Planning Application Technical Response

Site:	Land at Woodgate Nurseries, Lidsey Road, Woodgate
LPA Reference:	AL/89/24/OUT
Date Assessed:	05 September 2024

LLFA Response To Planning Application Number AL/89/24/OUT at Land at Woodgate Nurseries, Lidsey Road Email 2 of 2

SURFACE WATER DRAINAGE STRATEGY AREA 1

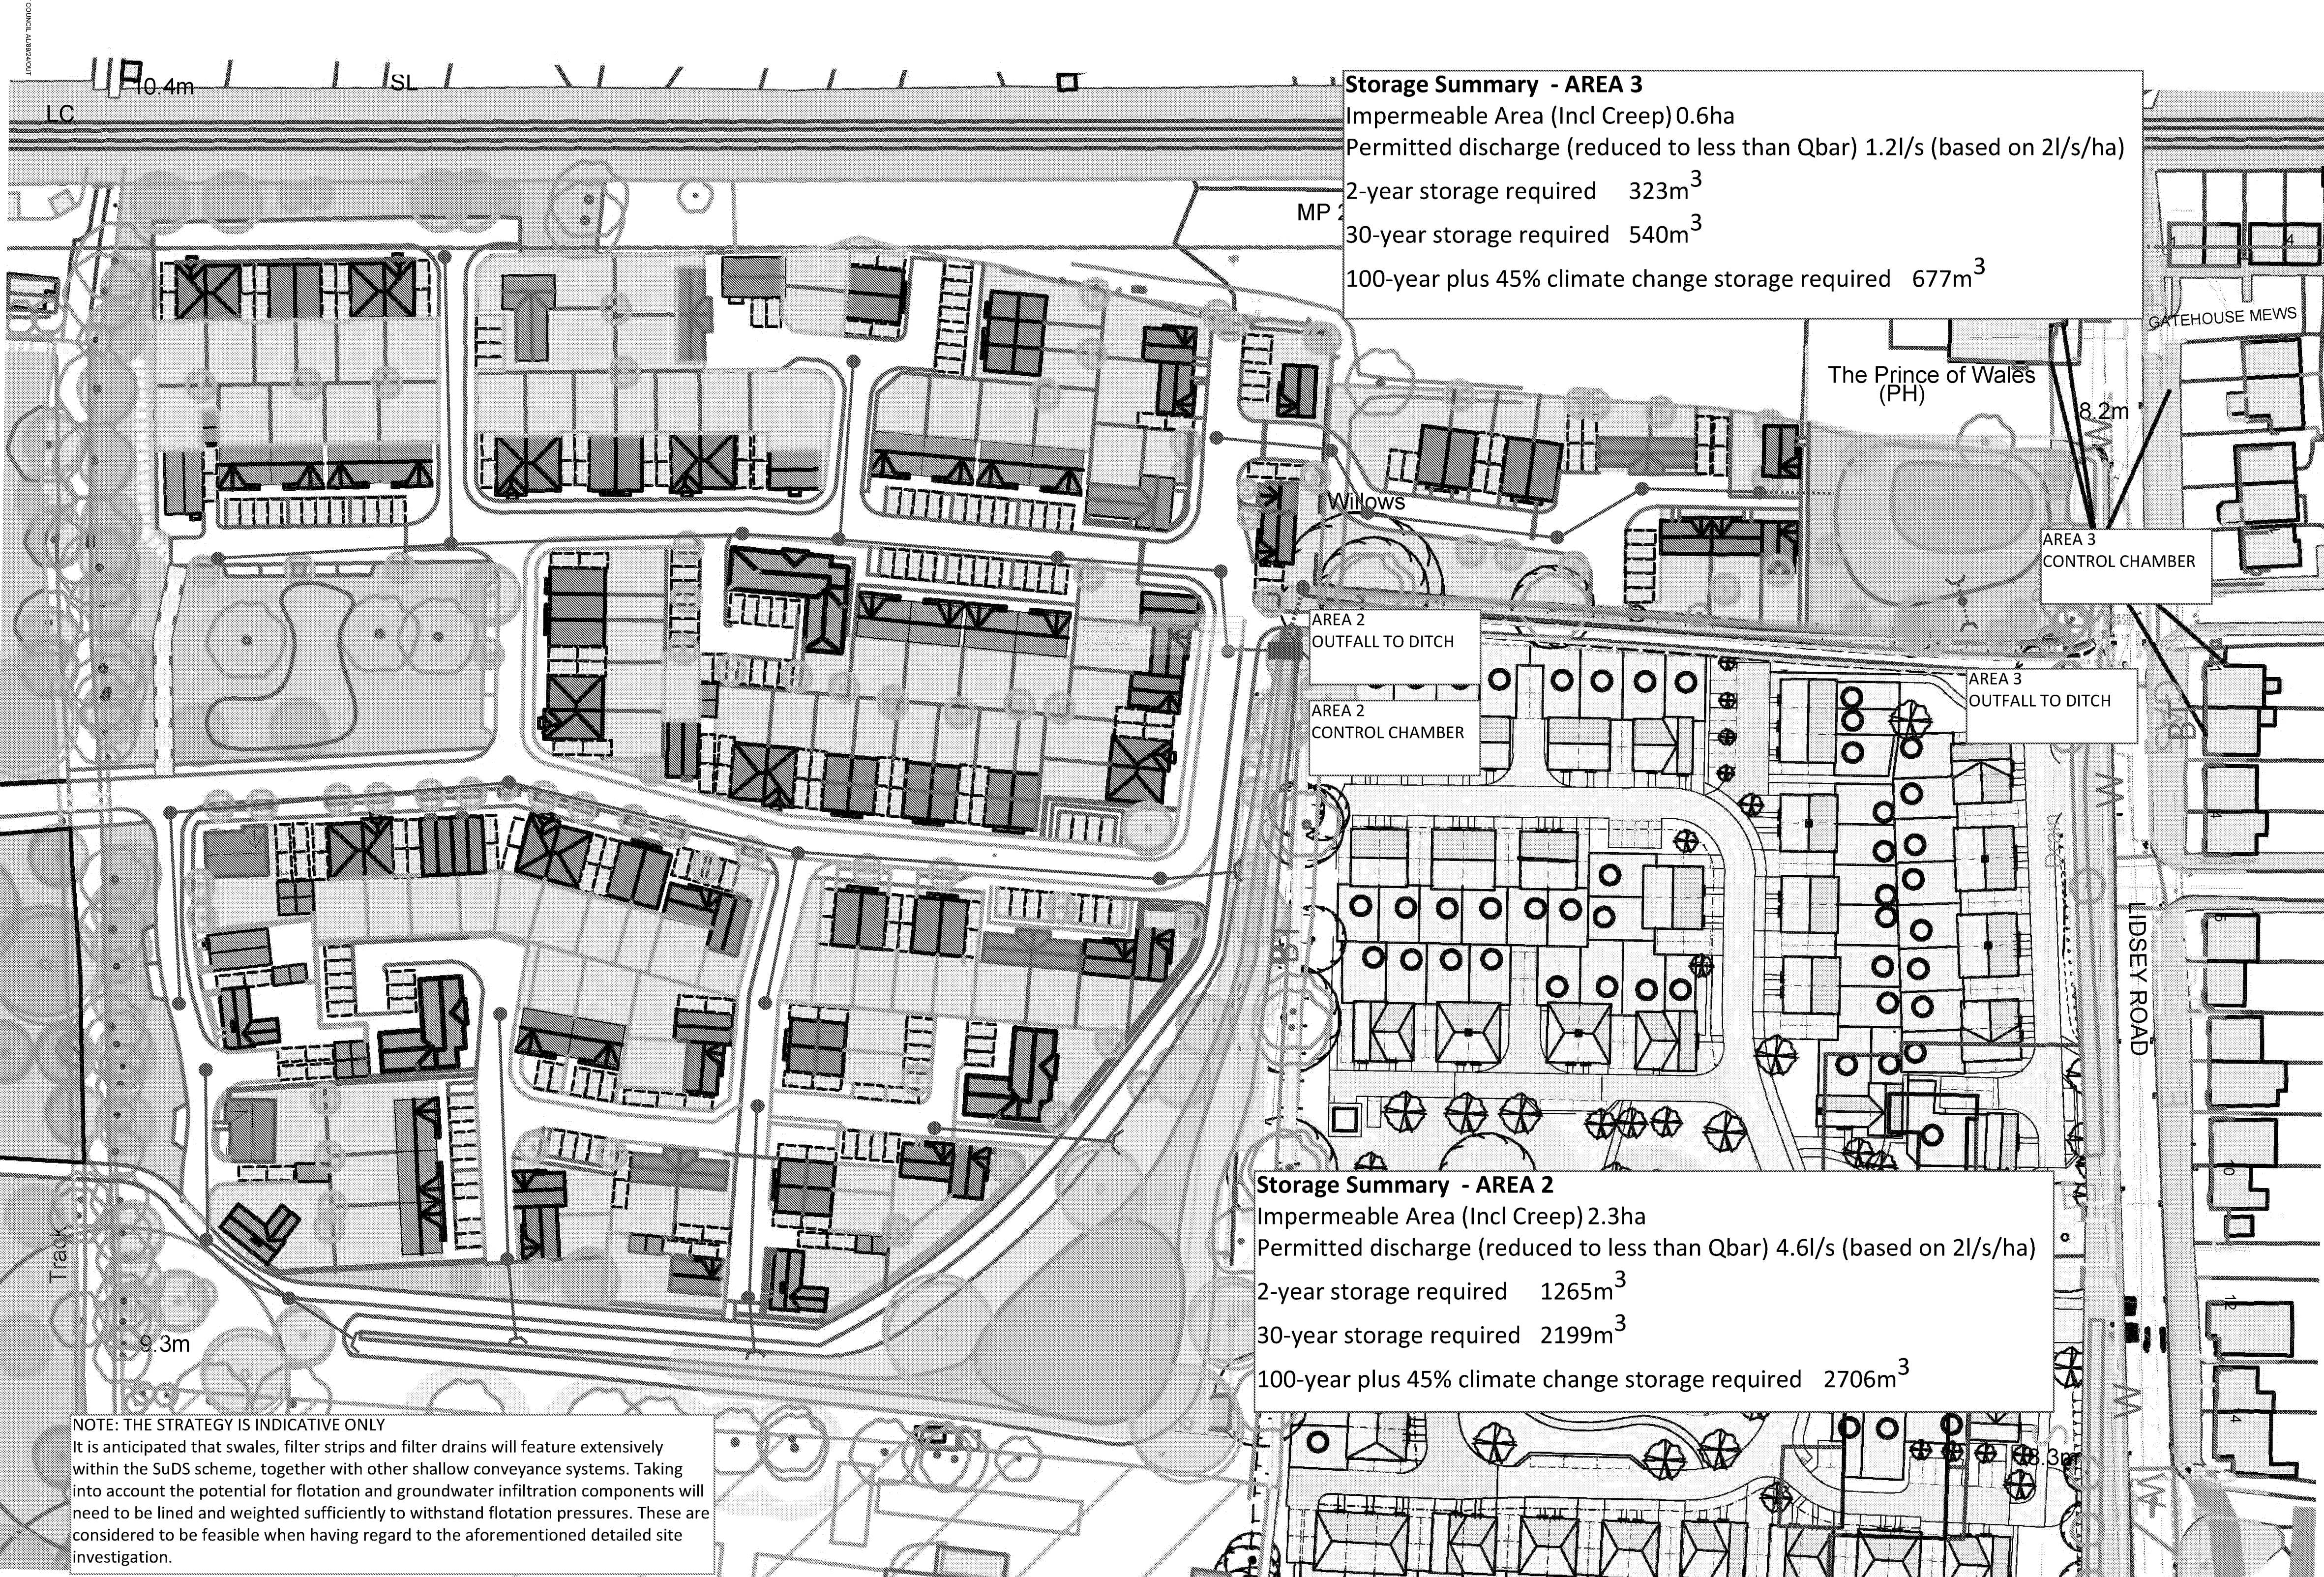
☐ Require justification and supporting calculations for brownfield % betterment and why this can't be closer to the predevelopment greenfield scenario.	
		☒ Proposed discharge rates would increase flood risk elsewhere and need to be re-assessed.	Objection: The proposed discharge rates are based on the impermeable area plus an allowance for urban creep, therefore discharge rates are higher than greenfield.

☐ Outline drainage modelling calculations should be resubmitted using a CV value of 1.	
		☐ Use up to date FEH2022 rainfall parameters in any modelling scenarios.	
Location of SuDS		☐ Masterplan drawings need to show the high-level location of all SuDS and demonstrate that the volume of storage can be achieved in the layout.	
		☐ Address concerns that there is not enough room within the masterplan for all SuDS features e.g. sufficient room for swales along main roads and still achieved the required density of the development.

OUTLINE APPLICATION	Related Policy or Standard	Applicant Action Required	LLFA Specific Comment
How will the drainage and watercourse features be managed and maintained?	NPPF Paragraph 175 PPG Paragraph 055, 057 and 058 SDNSTS S10, S11, S12, S13 and S14	☐ High level assessment of the maintenance of any SuDS features and structures and who will be adopting these features for the lifetime of the development.	
		☐ Appropriate easements (to the adopting authority standard) to SuDS features should be shown on a drawing, this will be a minimum of 3m.	
		☐ Indicative vehicular access route and off-road parking needs to be provided to ponds, basins and swales within the masterplan.	
		☒ Provide an easement of a minimum of 3 m from the top bank of any watercourse is required for maintenance of the watercourse. This should be on both banks, but justification should be provided if access is proposed from only one side of the bank or less than 3m (e.g. 2.5 times the width of any plant likely to be used (from the top of bank with maintenance plant parallel to the watercourse)).	Objection: Please show on drawings.
